Kirklees Metropolitan Borough Council  
Development Management

**Our ref:** RA/2025/148458/02-L01  
**Your ref:** 2025/91370

**Demolition of existing dwelling and erection of 50 dwellings with associated access, infrastructure and associated works**

**Land at, Gynn Lane, Honley, Holmfirth, HD9 6LF**

Detail
 ROAD 1 CULVERT/HEADWALL CONSTRUCTION DETAILS (DRAWING 10F2)

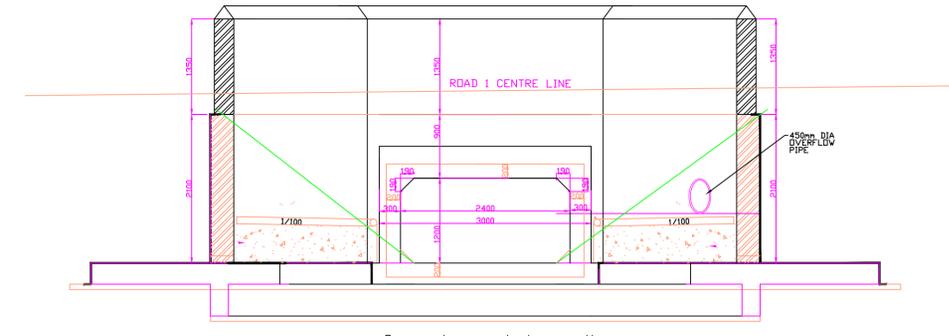
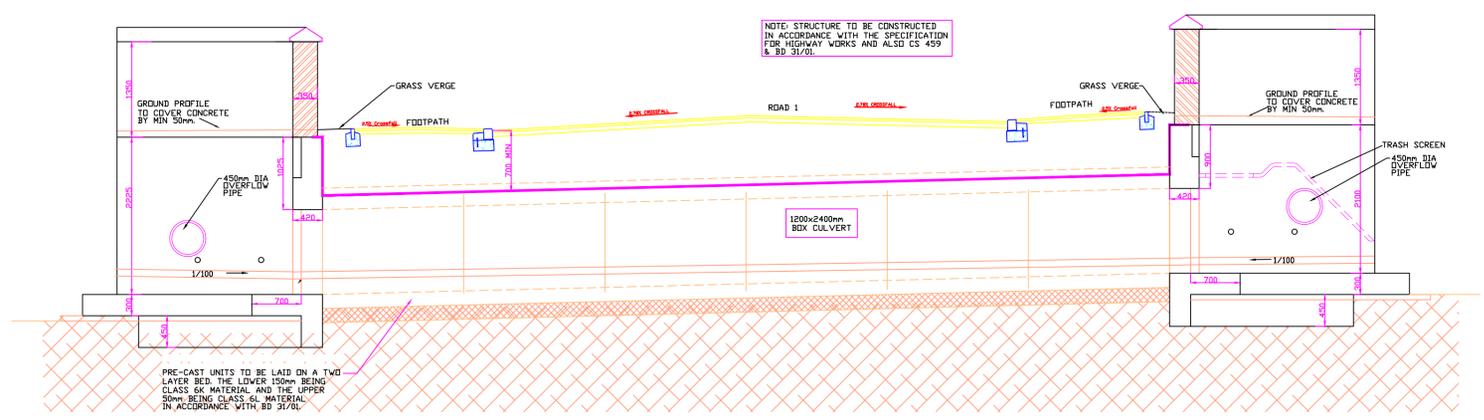
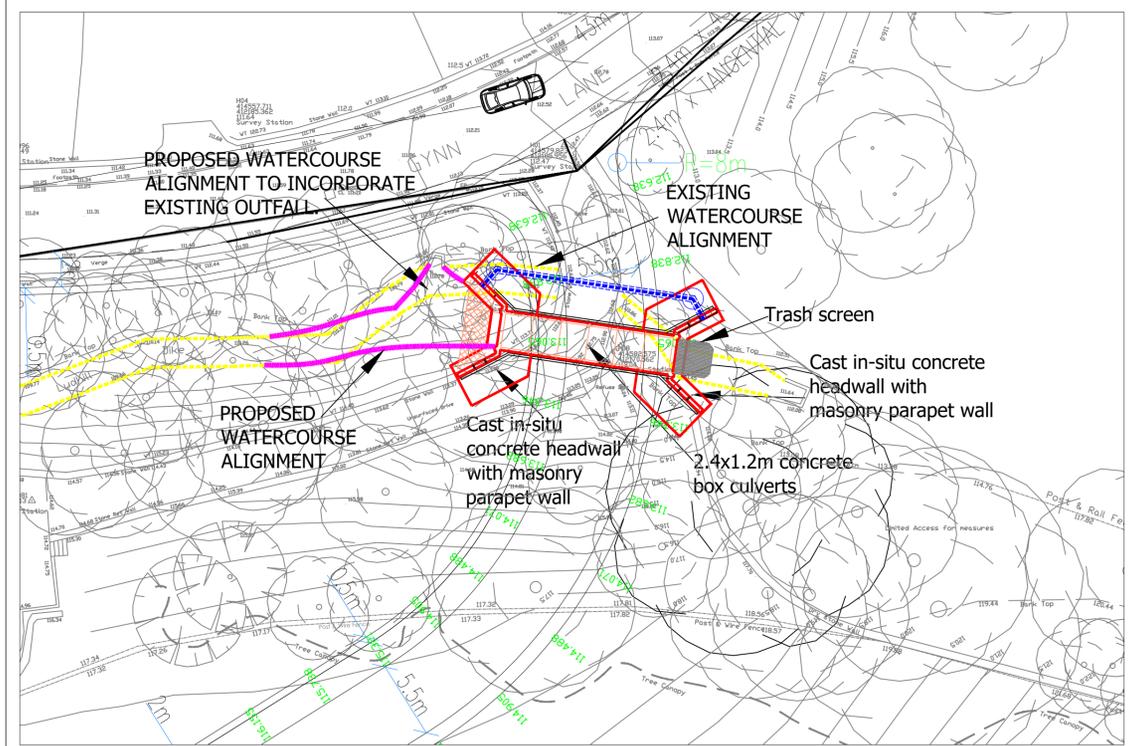
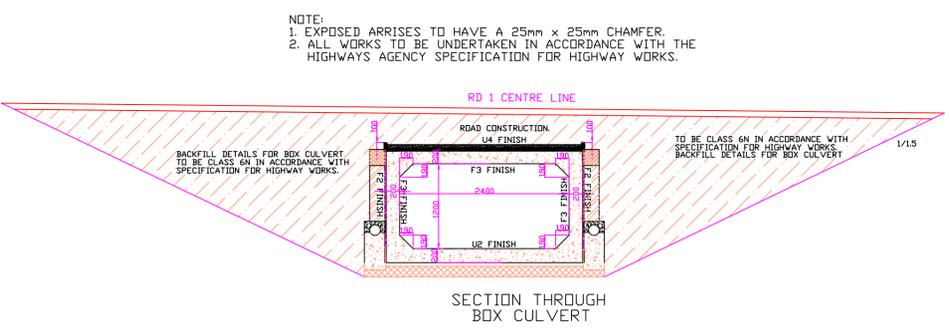
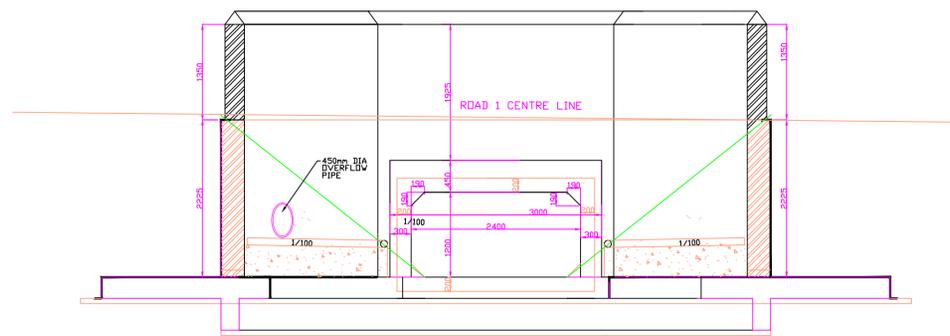
We note that the proposed development involves culverting an ordinary watercourse. We are generally opposed to culverting watercourses due to the detrimental impacts on flood risk and the environment, and therefore recommend that the applicant considers a clear span bridge rather than a culvert. However, as the watercourse in question is an ordinary watercourse, we do not formally object to the proposed development and defer to the Lead Local Flood Authority for comment.
